WELWYN HATFIELD COUNCIL – DEVELOPMENT CONTROL
DELEGATED REPORT

APPLICATION No:	S6/2011/0970/FP
------------------------	------------------------

PROPOSED ROOF PLAN

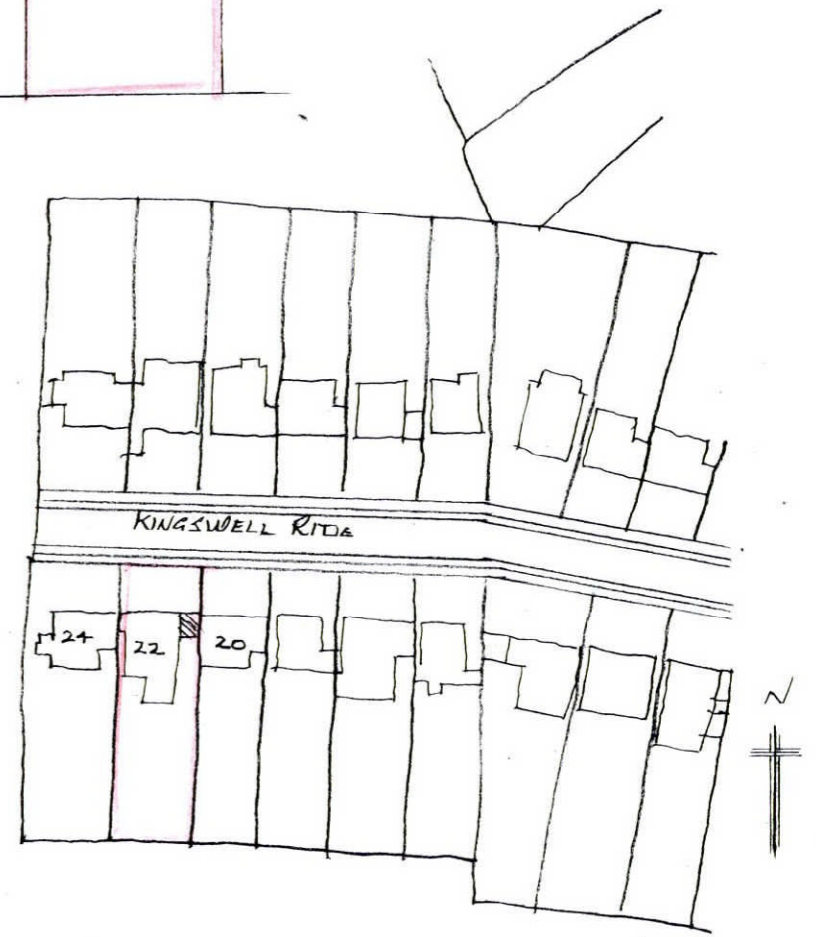
Due to the separation between the application dwelling and neighbouring properties the proposed hip to gable alteration would not appear too bulky or overly dominant. The proposed roof design would reduce the ridge length of the roof and introduce a much lower roof to the rear of the property. The resultant roof would maintain openness to the rear of the properties and prevent an adverse overbearing impact. The proposed side dormers would subordinate to the main roof and would not appear too dominant when viewed from the adjacent plots.

PROPOSED FIRST FLOOR PLAN

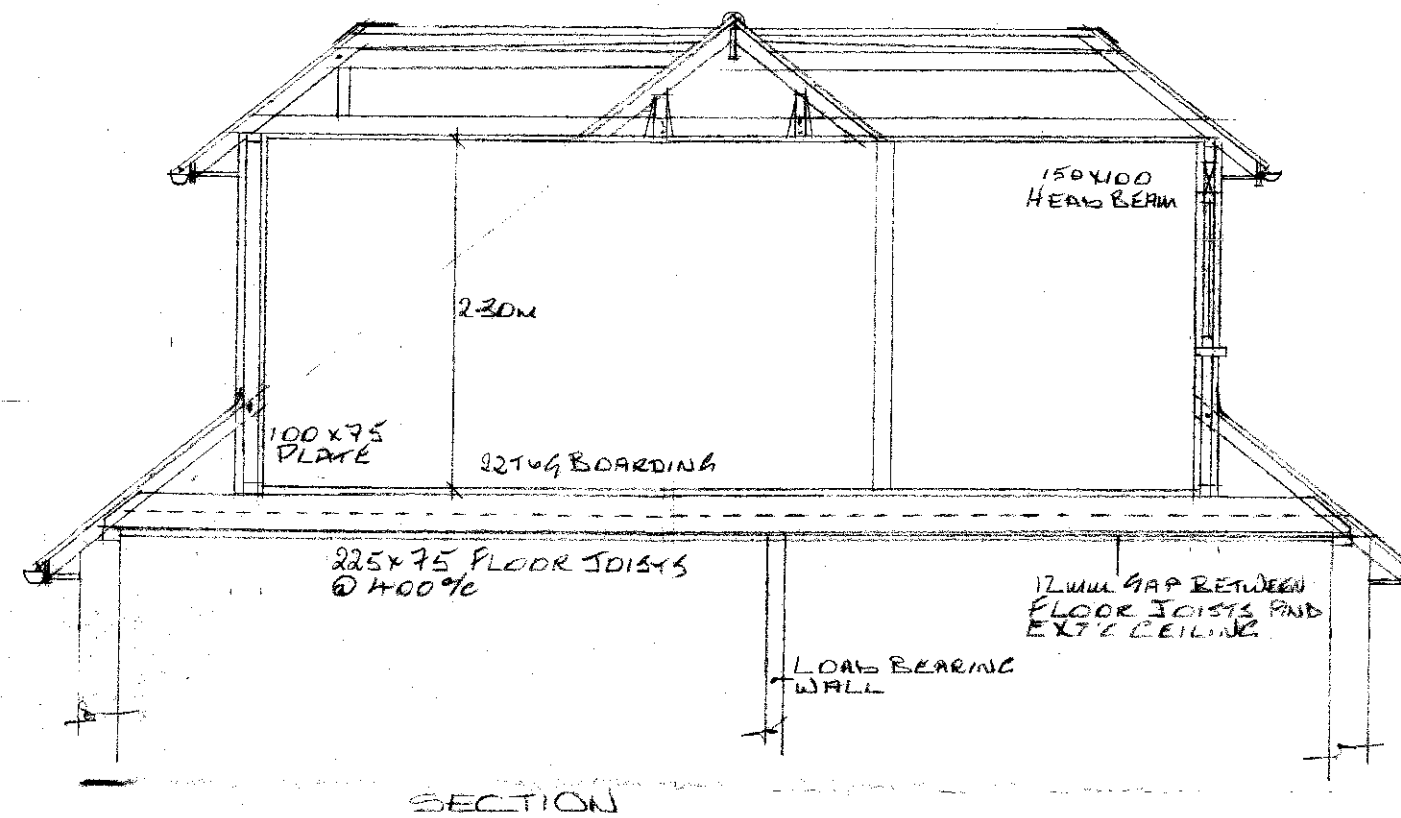
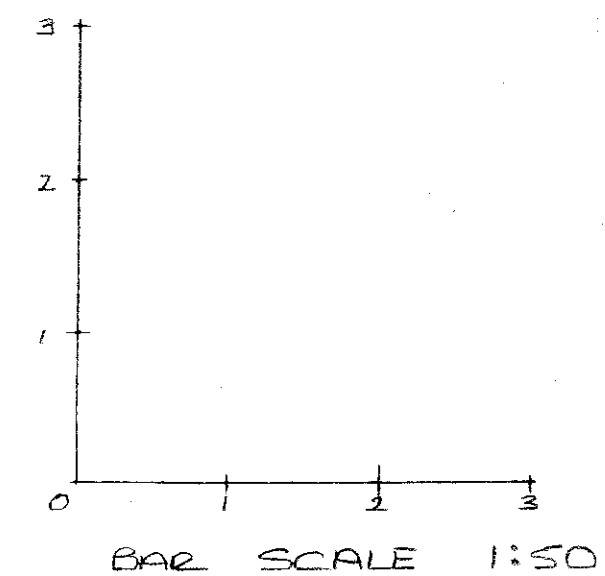
The proposed development would not result in any further overlooking or a significant loss of privacy to the adjoining occupiers. One of the proposed side dormers would not be glazed and the other would serve a bathroom. To ensure that the bathroom window remains obscure glazed a condition could be applied if consent is granted. The rear gable would contain a Juliet balcony, as this addition would not allow a significant sideward view it would mostly create an outlook to the rear of the plot. This area would not result in any significant further overlooking of the adjoining occupants. A rooflight proposed to the side plane of the roof would serve a staircase and would not result in a significant outlook over the neighbouring property.

1. C.2.1: Standard Time Limit (3 years)
2. C.13.1: Development in accordance with approved plans/details KR/02 & KR/03 & KR/04 received and dated 18 May 2011.
3. C.5.2: Materials to match the existing dwelling
4. The flank dormer window of the resultant building shall be glazed with obscured glass and shall be fixed so as to be incapable of being opened below a height of 1.7 metres above floor level, and shall be retained in that form thereafter.

LOFT CONVERSION, GARAGE EXTENSION
 AND ROOF ALTERATIONS
 22 KINGSWELL BIDE,
 CUFFLEY
 SCALE : 1:50 - 1:100
 DATE : MAY 2011
 DRAWING N° : KE/02
 DRAWING SIZE : A2

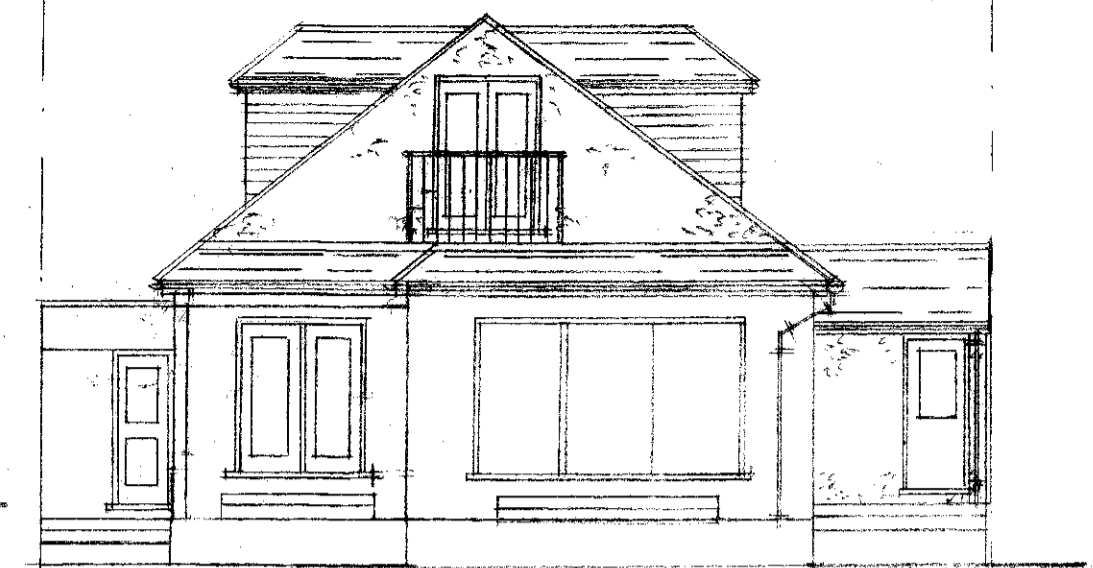
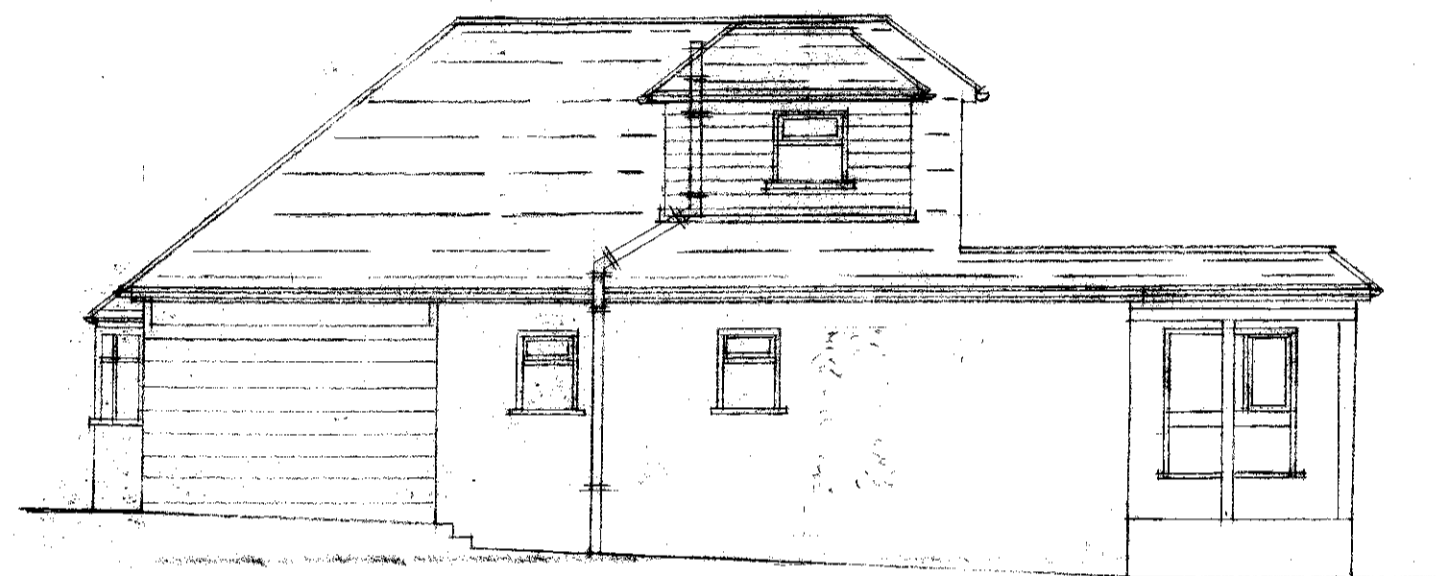
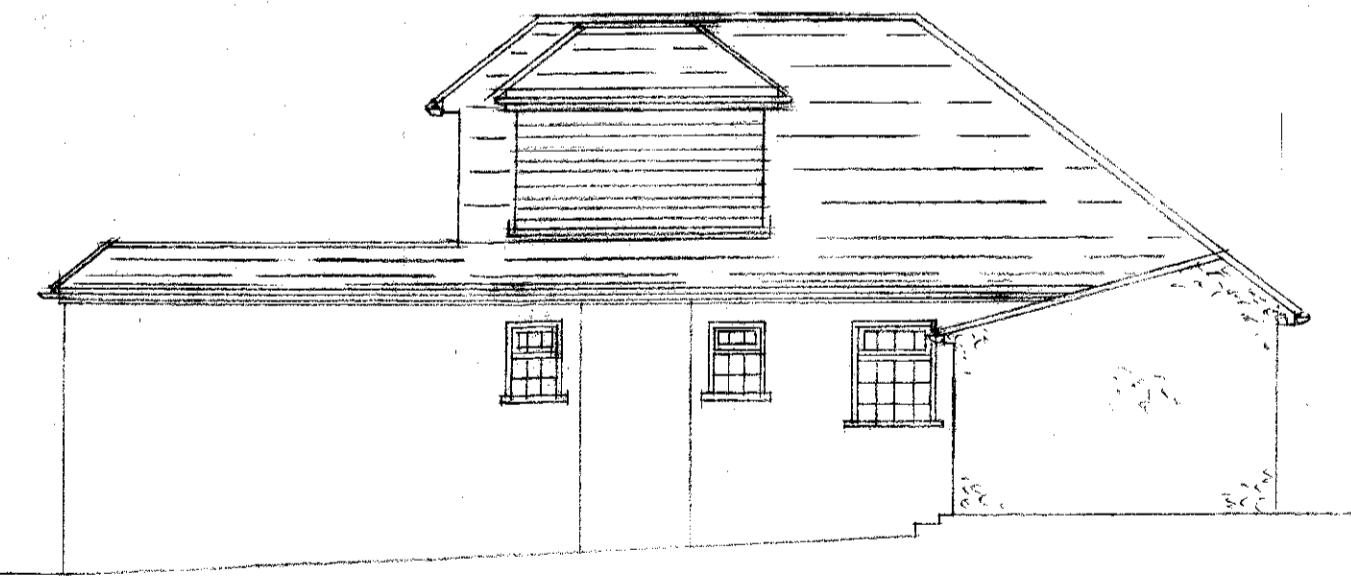
1. A modest alteration would be made to the front elevation of the dwelling to give the garage a pitched section of roof that would be connected to the main roof of the dwelling. This roof would also create a canopy over the bay windows which are within the front elevation of the property.

The proposed development would mostly be sited to the rear of the property and the proposed dormers would be set back from the front elevation of the dwelling. The siting of the proposed extensions would prevent the development from appearing too prominent or very noticeable within the streetscene and the public areas to the front of the property.

The proposed dormers would be set down from the main ridge and maintain an appropriate distance from the eaves of the property. The sides of the dormers would retain an acceptable distance from the edges of the roof and the dormers would appear subordinate to the main roof. Although the side dormers would be less than 1m from the rear gable, this arrangement would not be too noticeable from the surrounding area. The proposed dormers would be similar to existing additions to other properties within the locality of the application site and the proposal is considered to be acceptable in terms of design. It has been noted that the glazing to the proposed dormers would be limited. Although the lack of glazing would not break up the appearance of the dormers, there are several similar examples within the locality. Due to the dormers being set back from the frontage of the property they would not appear overly prominent or have an adverse impact upon the character and appearance of the surrounding public areas.

The proposed roof extension and hip to gable alteration would be similar to existing additions to nearby properties and would not appear out of place. This addition would not be viewed from public areas and would not affect the character and appearance of the streetscene. There are variations to the rear of the neighbouring properties and the proposal would not affect the character of the locality.

The proposed canopy area to the rear of the property would be set down from the main roof and would not appear prominent or dominant from the surrounding area.
